From: Martyn White
Sent: 31 August 2018 11:22
To: Anita Gardner
Cc: Planning.Responses
Subject: AB/81/18/DOC

AB/81/18/DOC

I note that the application relates to the provision of a new gate to the rear of the property in a former opening. The application included a picture of the proposed style of the gate, which it is assumed was used to determine it.

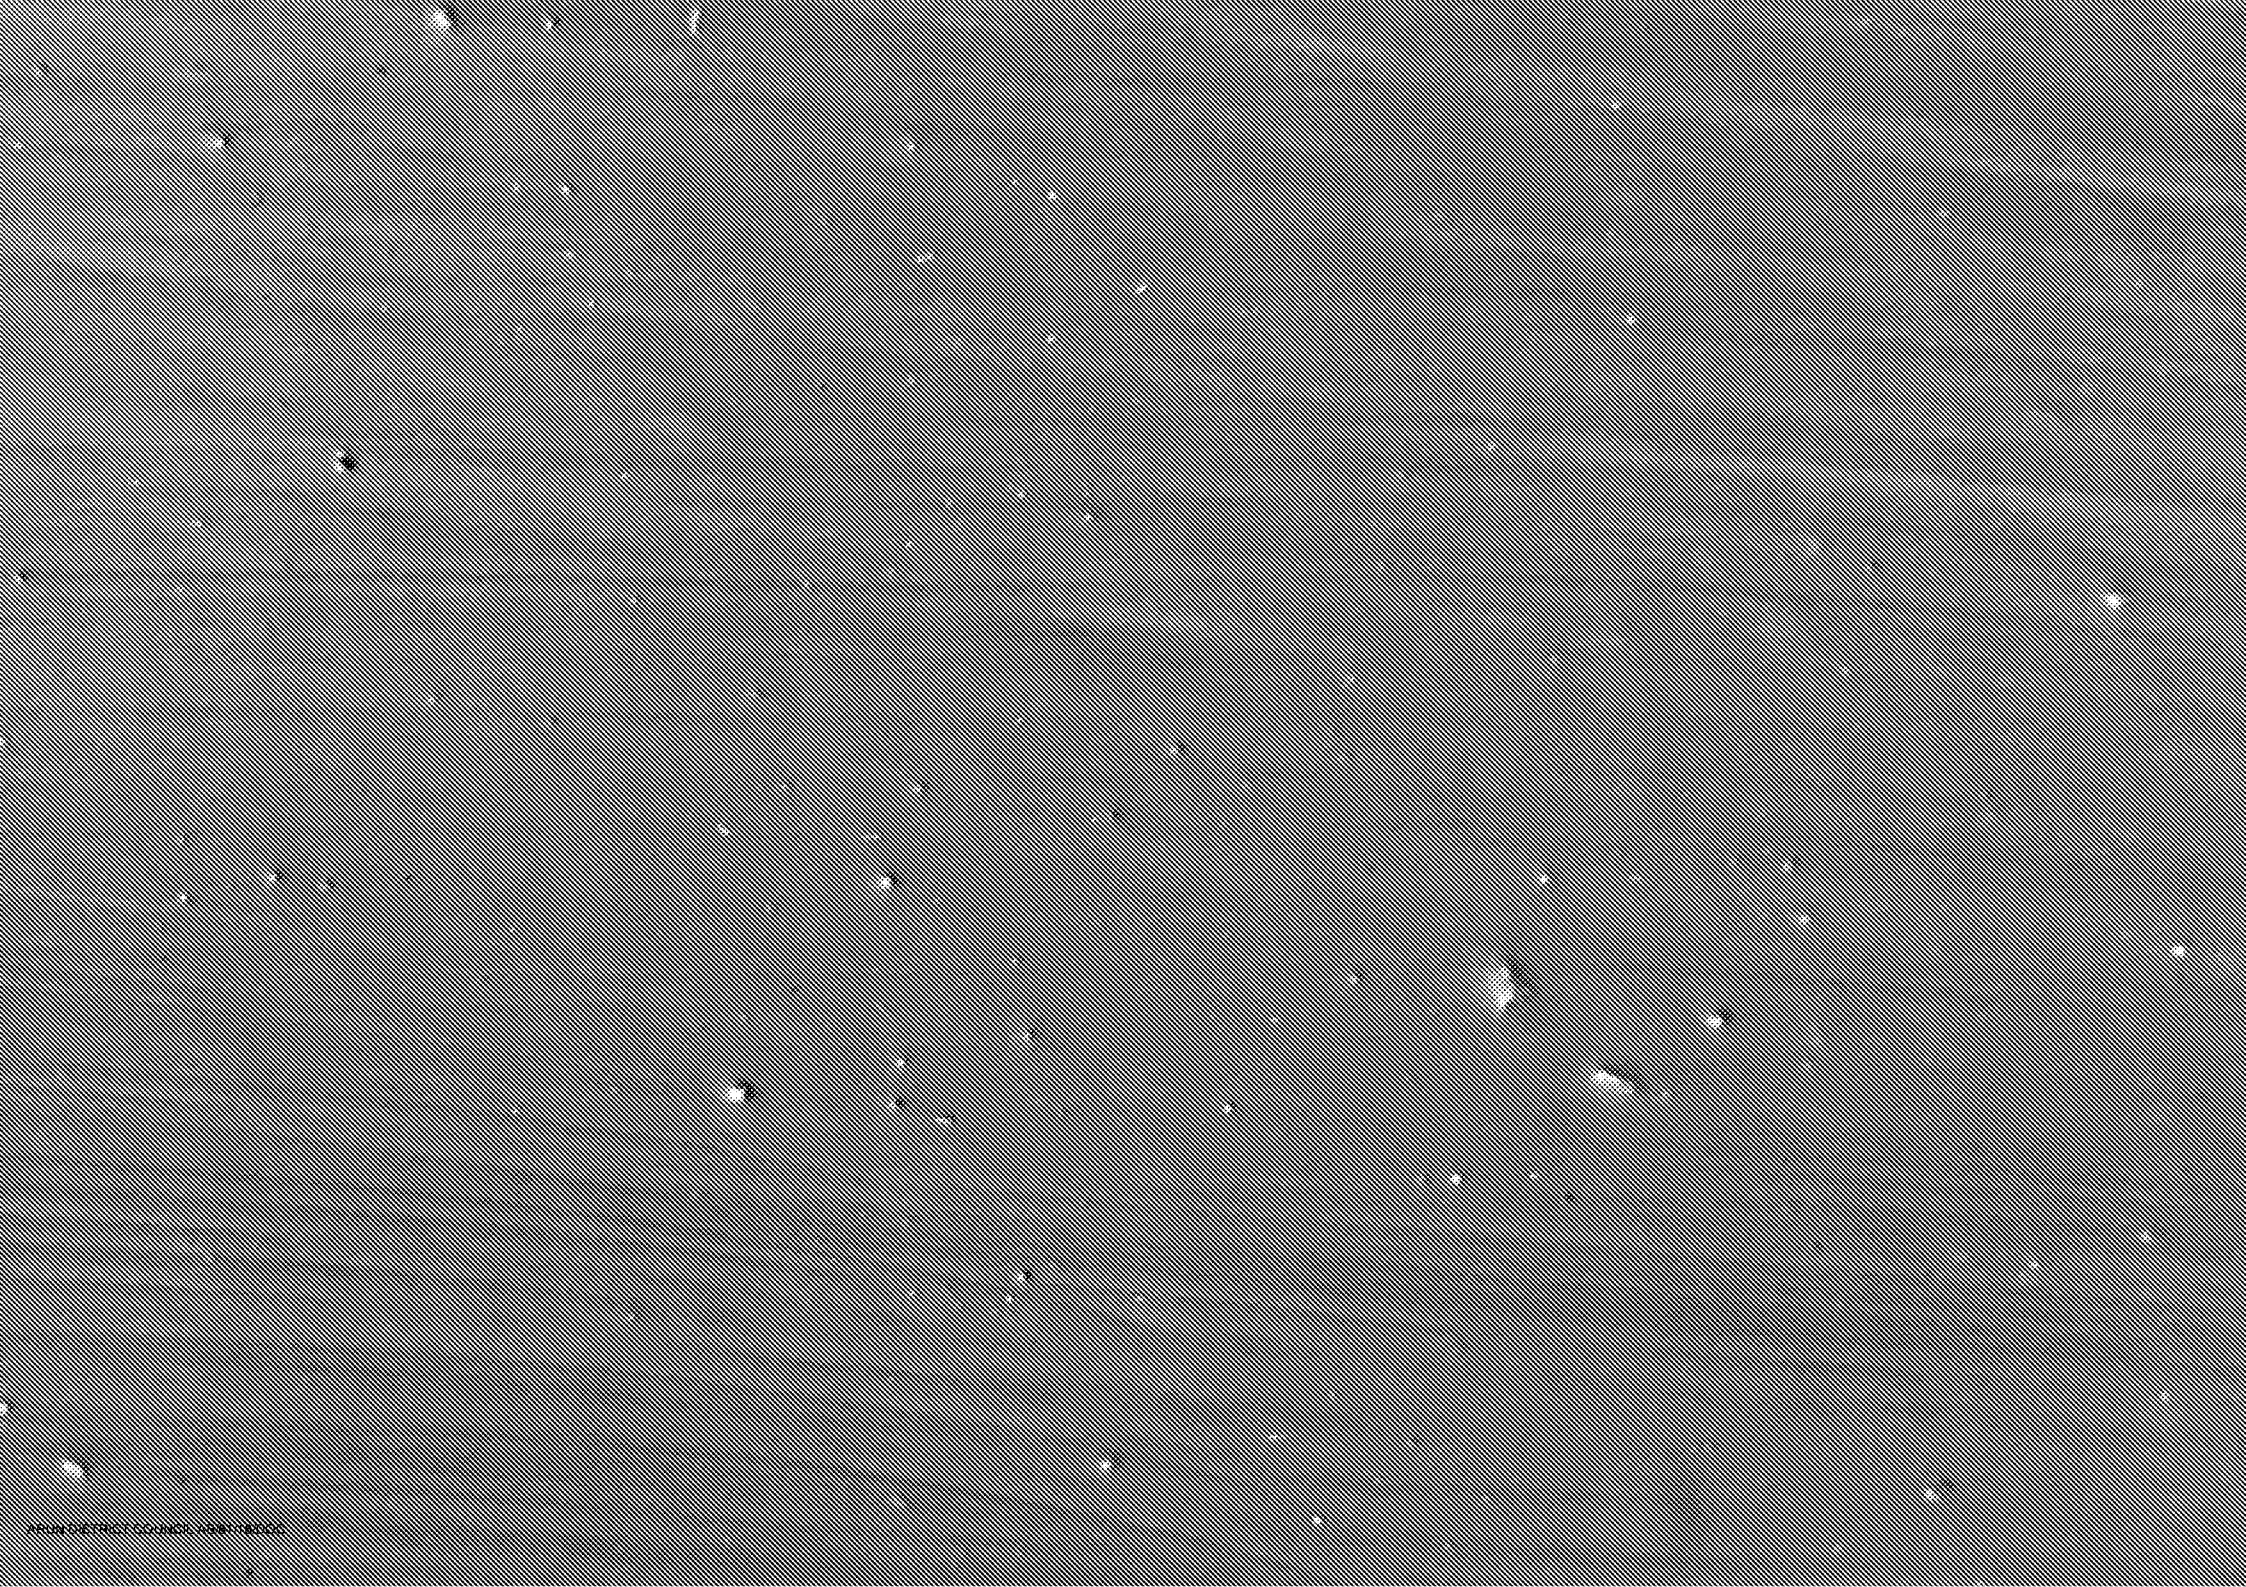
I note that the current application includes a description of how the gate will look. The concept of a solid gate is supported, however no picture has been provided as to its exact appearance. Further, it is not clear what the handle will look like, or what the exact colour will be (is it dark blue?) such information will be needed, even if it is in the form of a photograph with relevant information?
